Final Drainage Report_V1.pdf Markup Summary

Cornerstone Estates

POND
OUTLET STRUCTURE PLAN
SCALE: 3/8"=1'

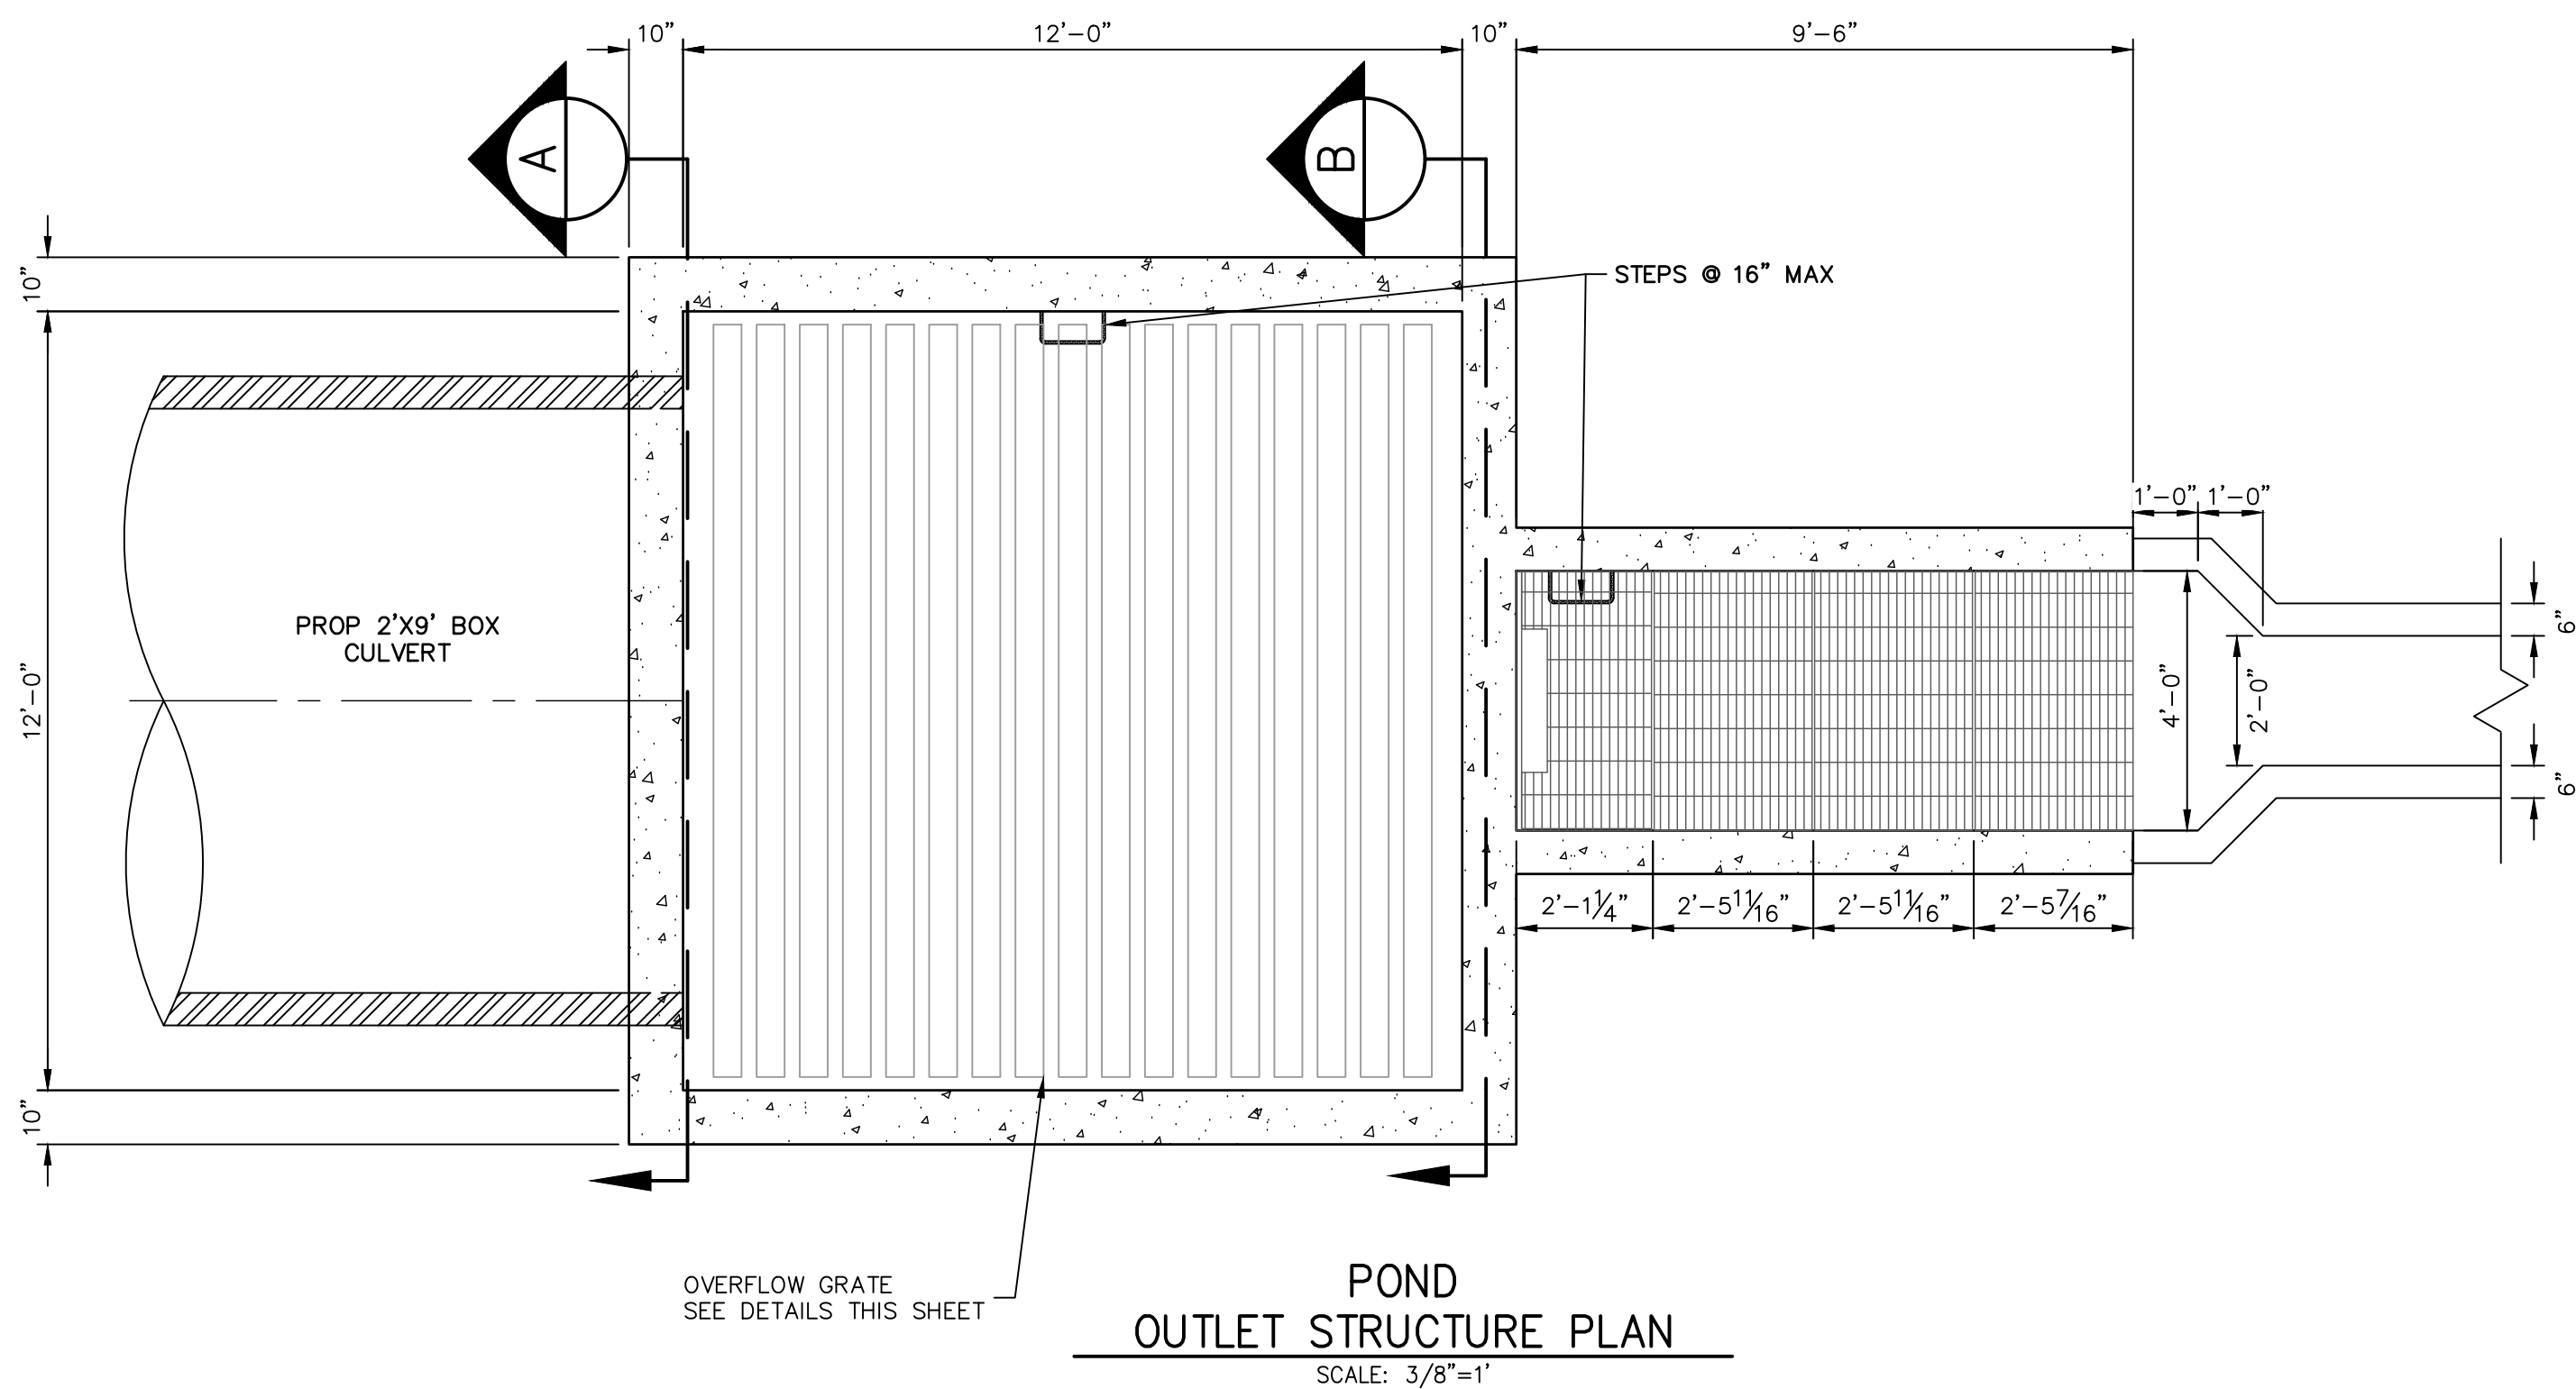
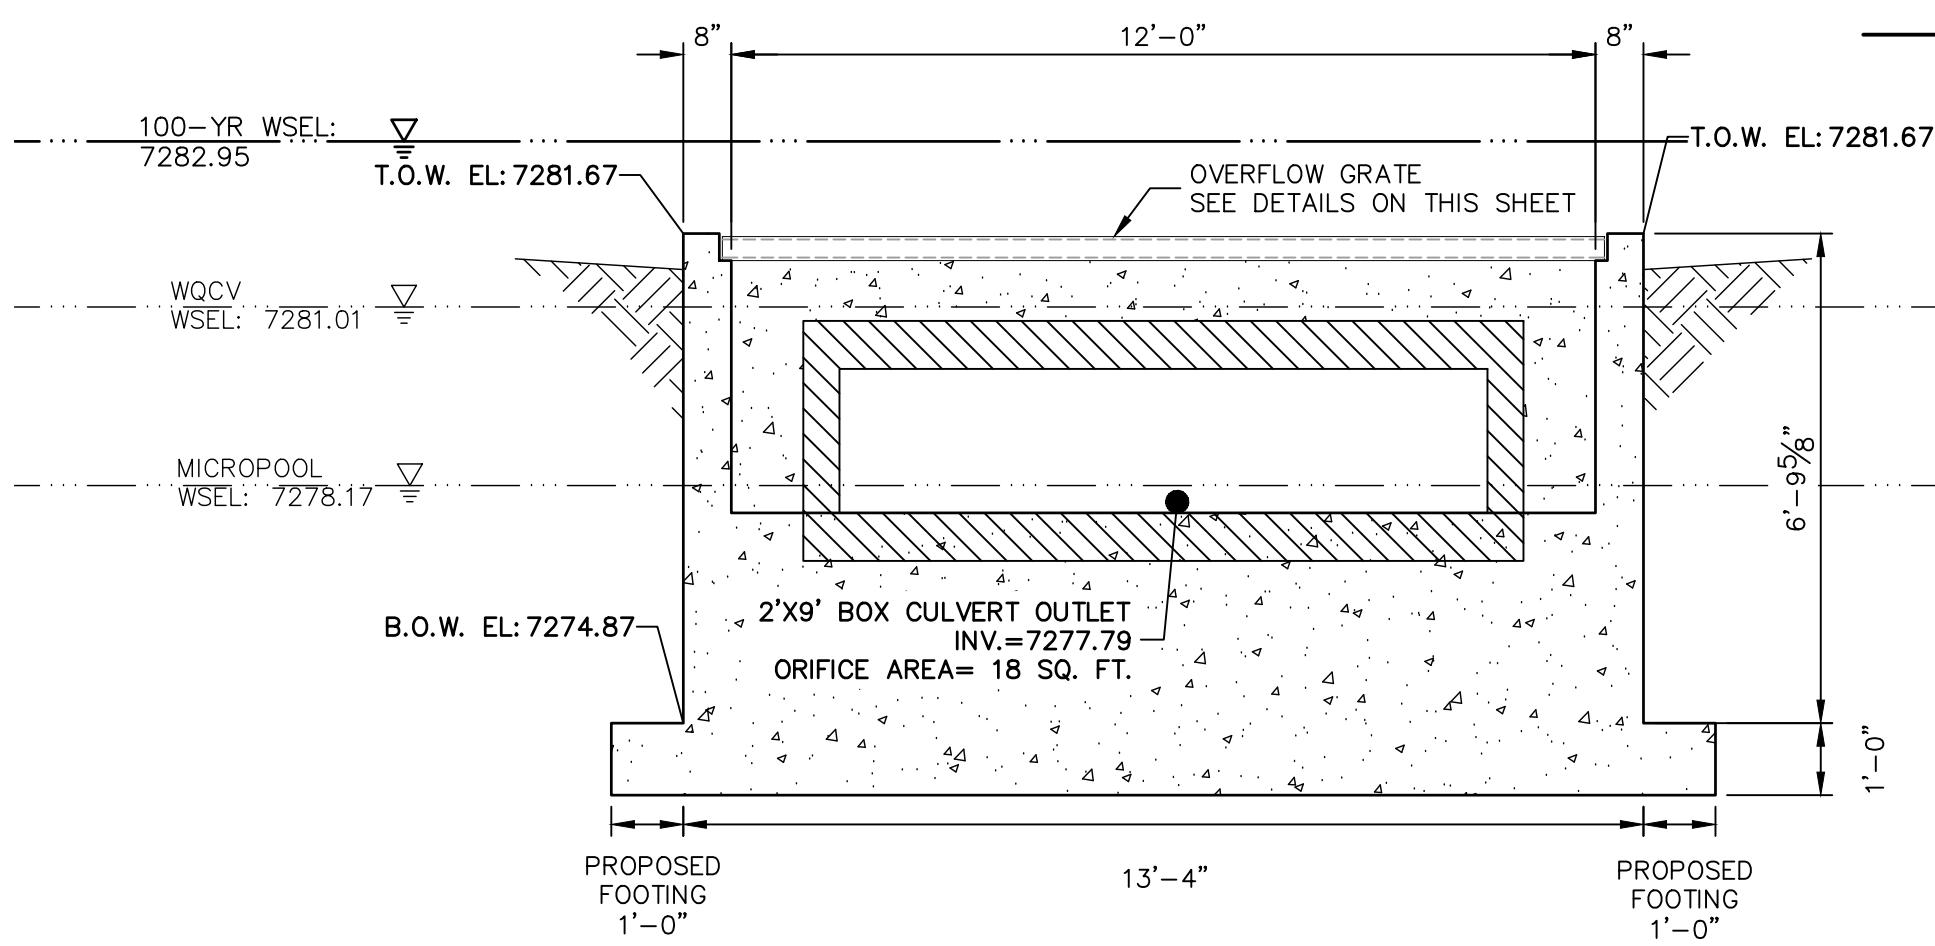
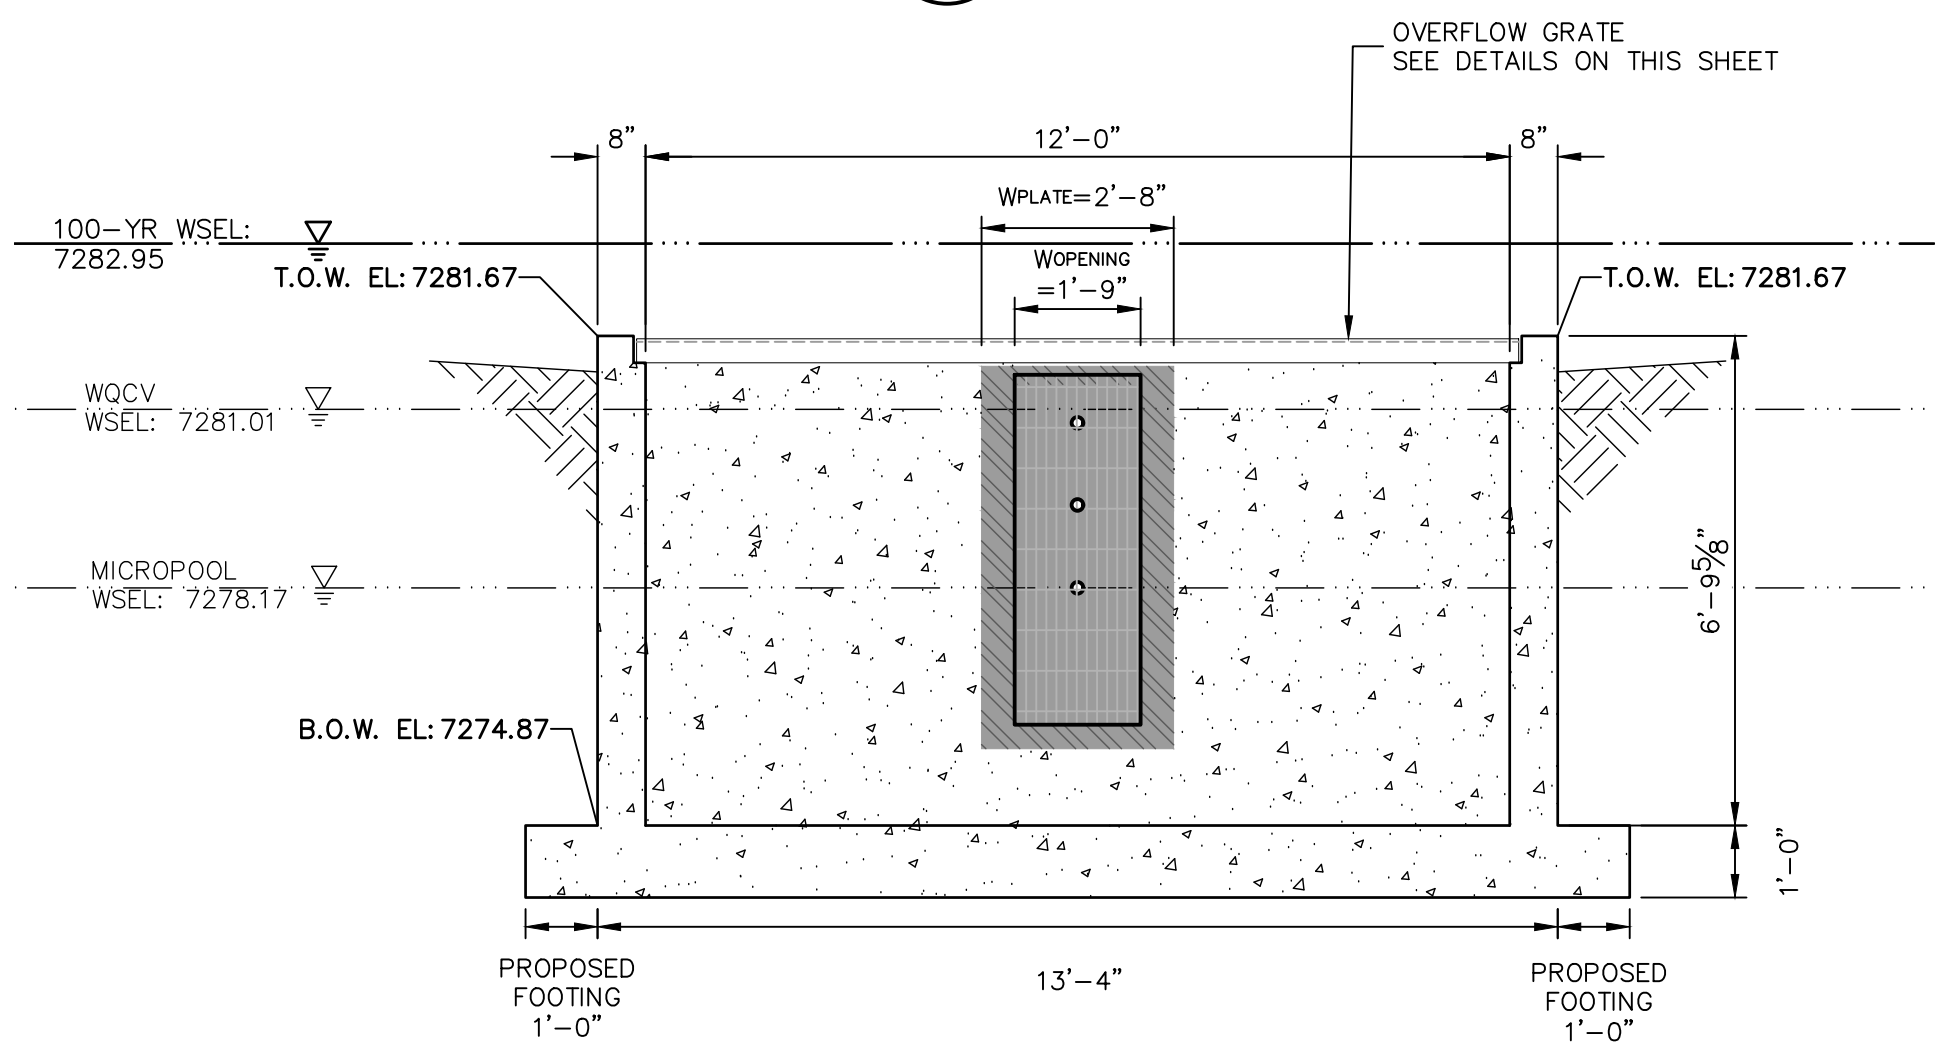
Also include discussion on trickle channel, emergency spillway riprap sizing and if cutoff wall is needed and maintenance access.

Section A-A: Capacity Check DP4 to DP5.1 and DP2.1 to DP12.1

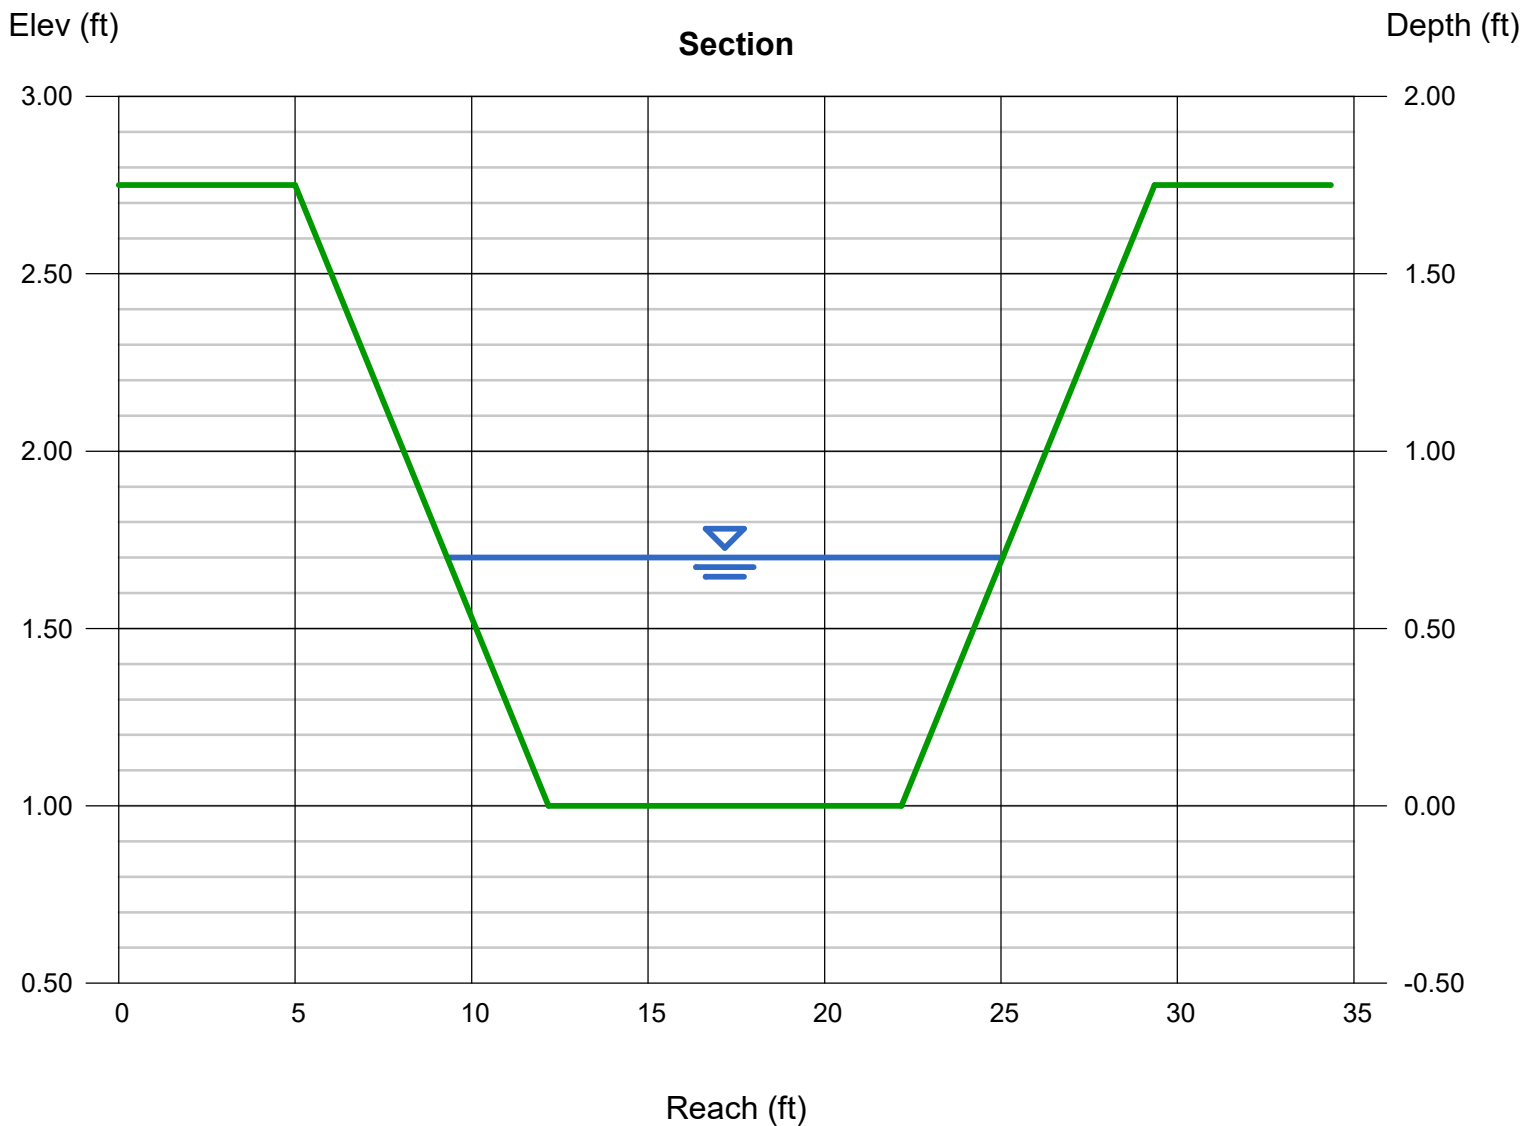
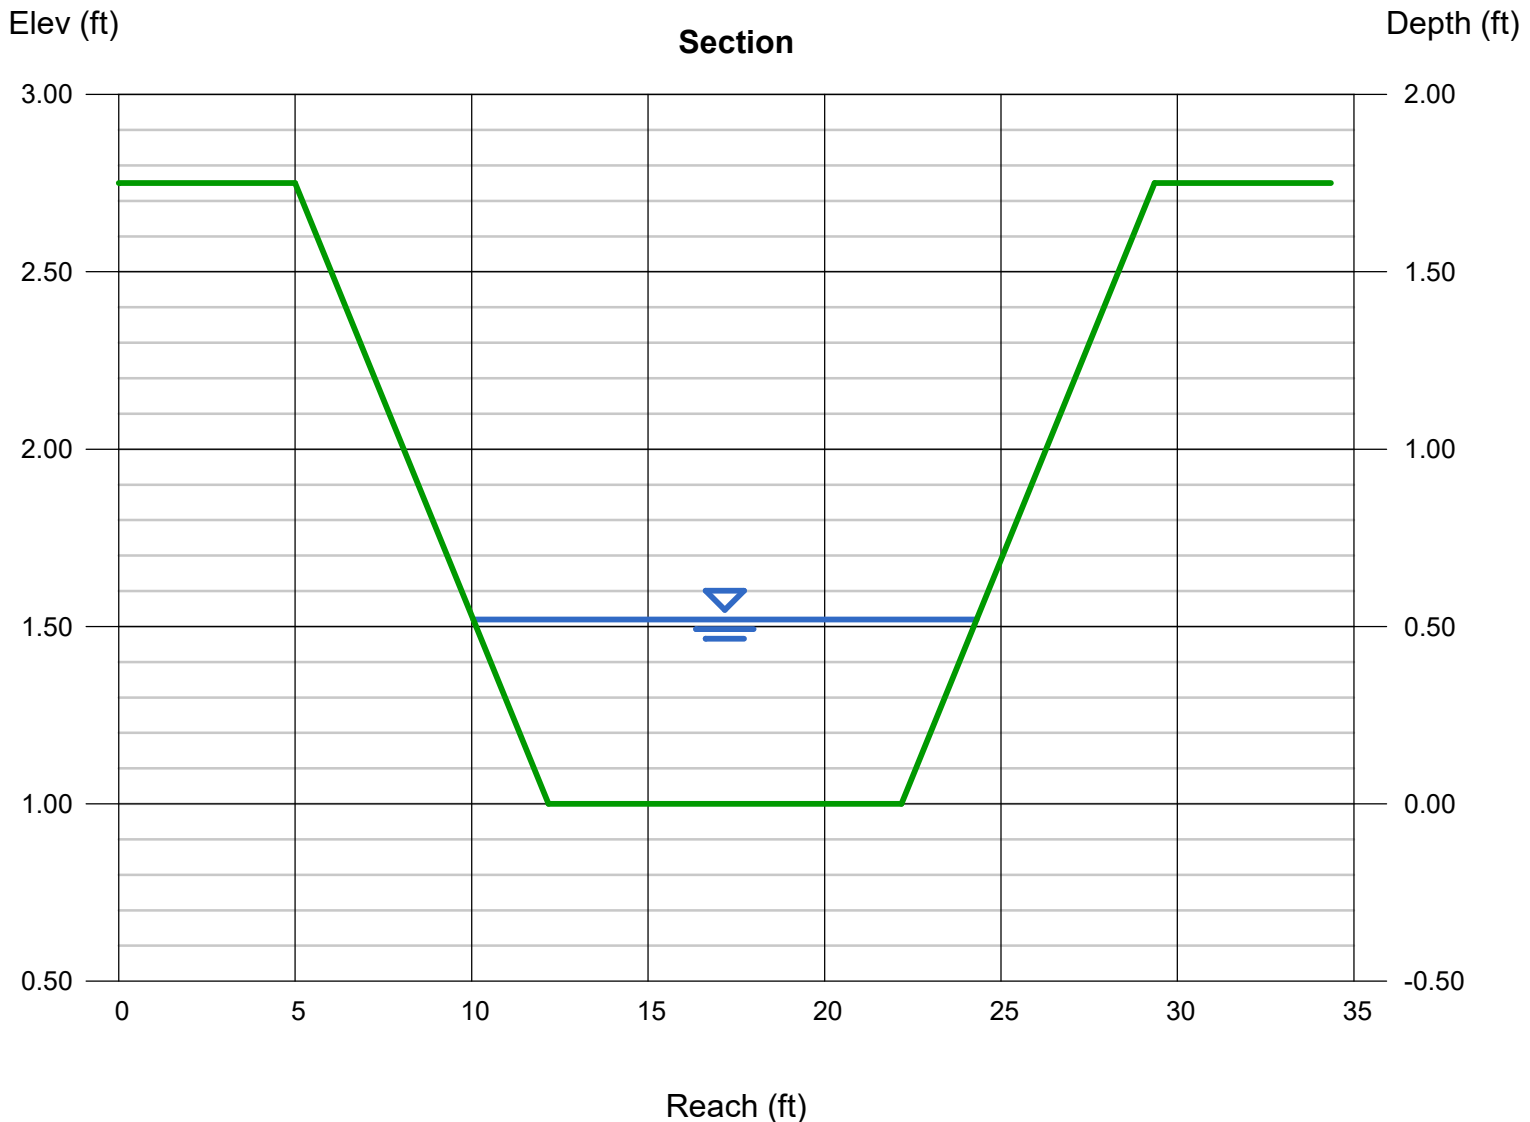
Please run separate analysis for DP2.1 to DP12.1
as it has a larger flow rate.
